CITY OF ALBUQUERQUE

October 13, 2021

Re: Monterey Motel
2402 Central Ave SW
30-Day Temporary Certificate of Occupancy
Transportation Development Final Inspection
Engineer's/Architect's Stamp dated 3-4-20 (J12D032)
Certification dated 10-6-21

C-101

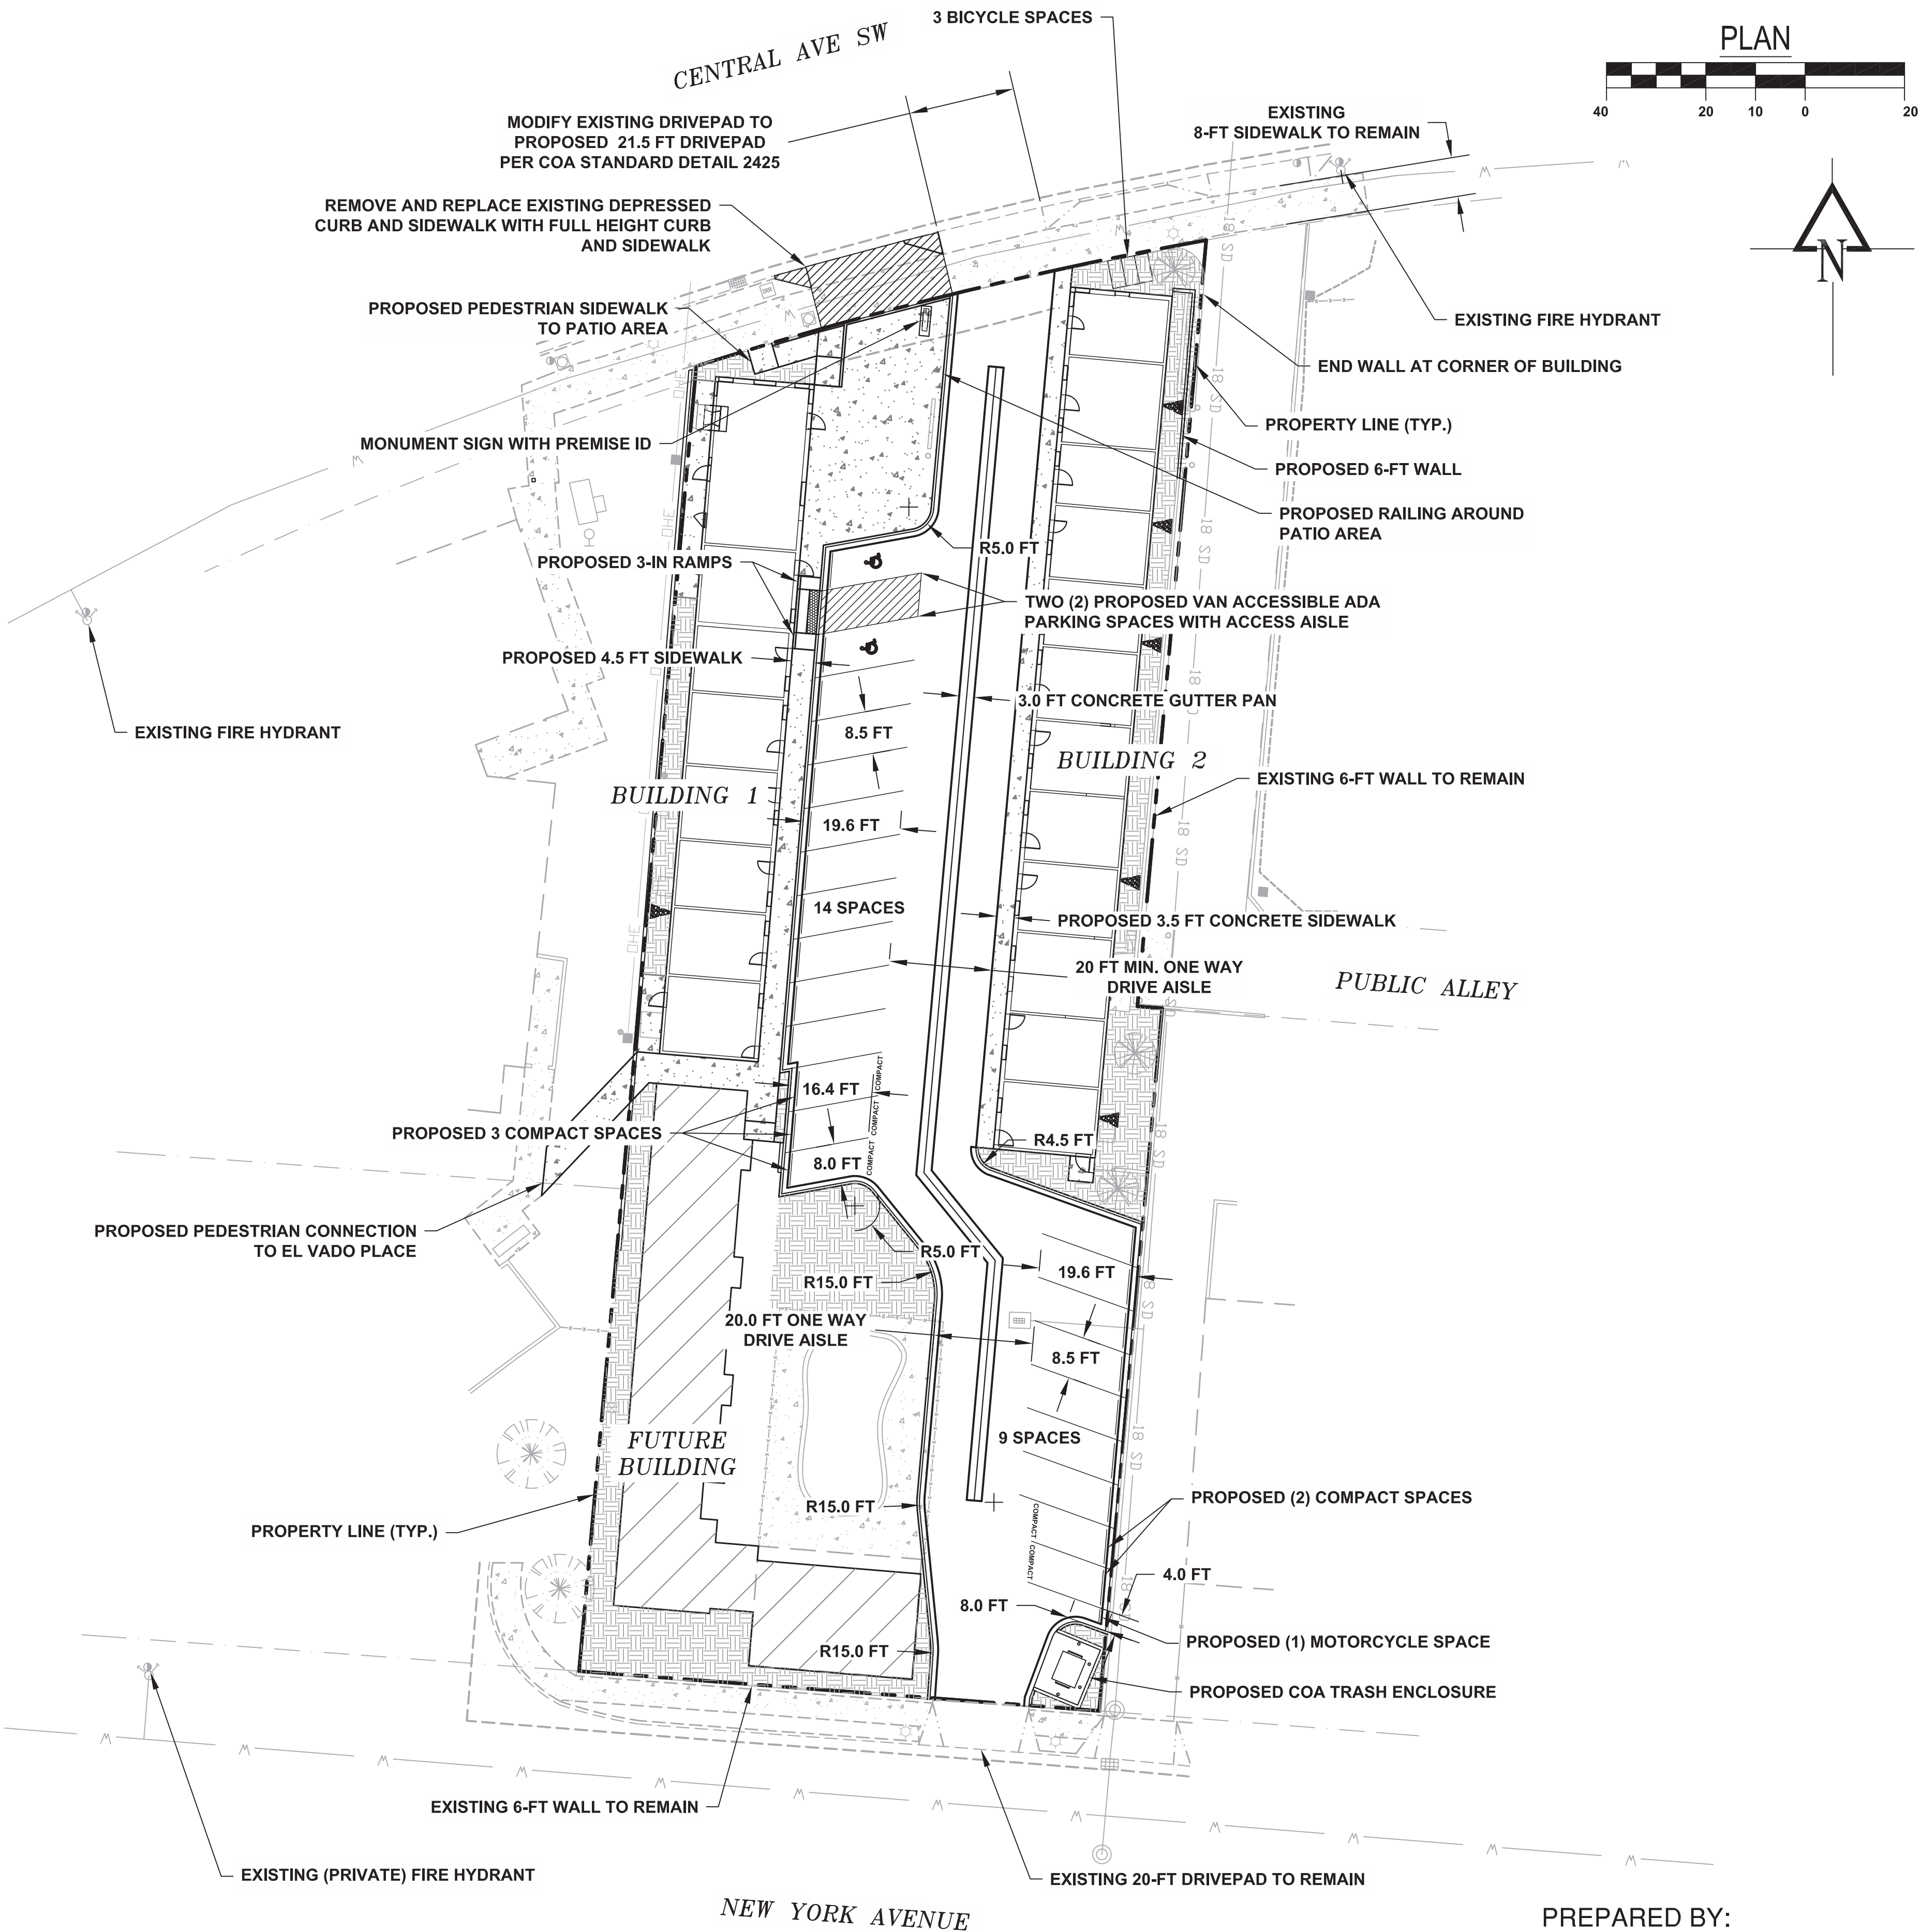
- Please add Motorcycle Sign & MC floor markings.
